REPORT UPDATE

Application No: LU/197/17/PL

Recommendation Report for Planning Permission

PROPOSAL: Change of use of existing leisure use of upper ground floor to form 3 No. flats, extension of first floor to form 2 No. flats & creation of 1 No. flat in roof space (resubmission following LU/395/14/PL & LU/84/16/PL).

SOUTH ELEVATION BIN/BIKE STORE

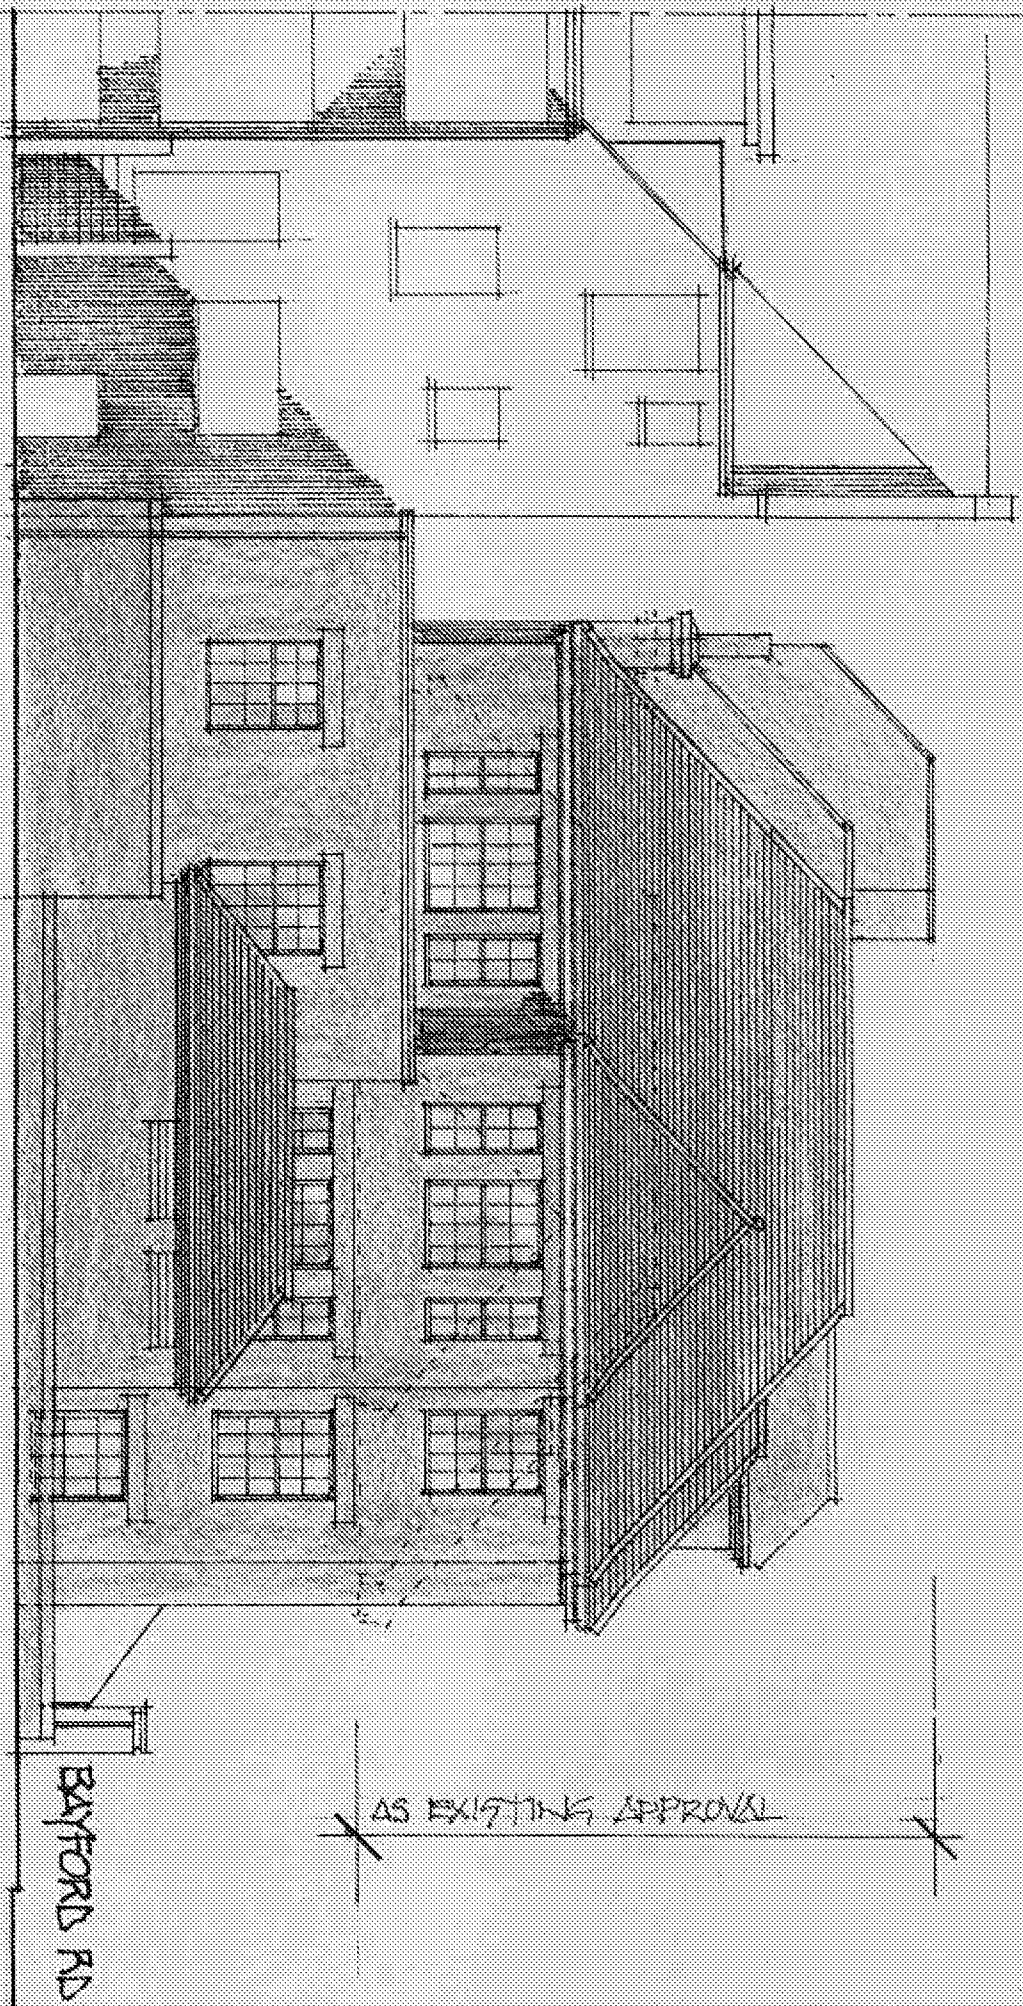
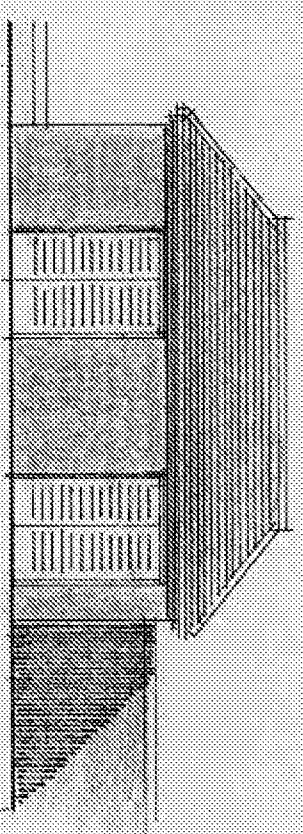
Can you confirm that the proposed bin store can be accessed when all the parking spaces are being used and lack of access will not lead to bins being left on the street edge all week?

There is no reason why the parking spaces should prevent the movement of dustbins. There would be space around them even if all spaces are occupied and the spaces are unlikely to be utilised all of the time.
